OXFORDSHIRE COUNTY COUNCIL'S RESPONSE TO CONSULTATION ON THE FOLLOWING DEVELOPMENT PROPOSAL

Application no: 23/02098/OUT

Proposal: Outline application, with all matters reserved, for a multi-phased (severable), comprehensive residential-led mixed use development comprising: Up to 215,000 square metres gross external area of residential floorspace (or c.1,800 homes which depending on the housing mix could result in a higher or lower number of housing units) within Use Class C3/C4 and large houses of multiple occupation (Sui Generis); Supporting social infrastructure including secondary school/primary school(s) (Use Class F1); health, indoor sport and recreation, emergency and nursery facilities (Class E(d)-(f)). Supporting retail, leisure and community uses, including retail (Class E(a)), cafes and restaurants (Class E(b)), commercial and professional services (Class E(c)), a hotel (Use Class C1), local community uses (Class F2), and other local centre uses within a Sui Generis use including public houses, bars and drinking establishments (including with expanded food provision), hot food takeaways, venues for live music performance, theatre, and cinema. Up to 155,000 net addition

Figure 2—1 Illustrative Masterplan

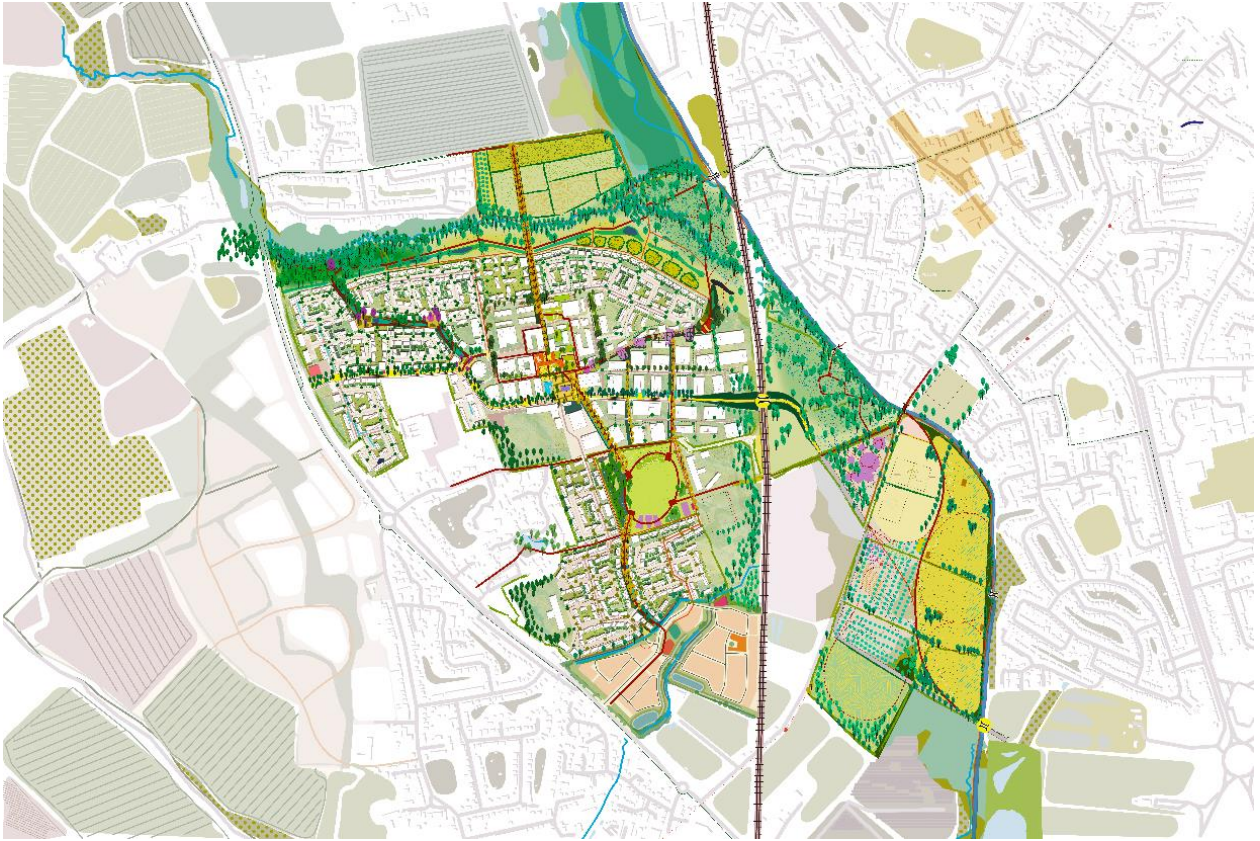
- Policy PR8 requires the safeguarding of 0.5 hectares of land for a potential future rail station within the allocation site. While the application does indicate that land has been safeguarded for, this only seems to appear as a rough hatched area in the Illustrative Materplan. I do not consider that sufficient information has been provided to clearly identify where the safeguarded land would be reserved, or to provide confidence that the access, maintenance and future operational requirements of a potential station have been appropriately safeguarded.
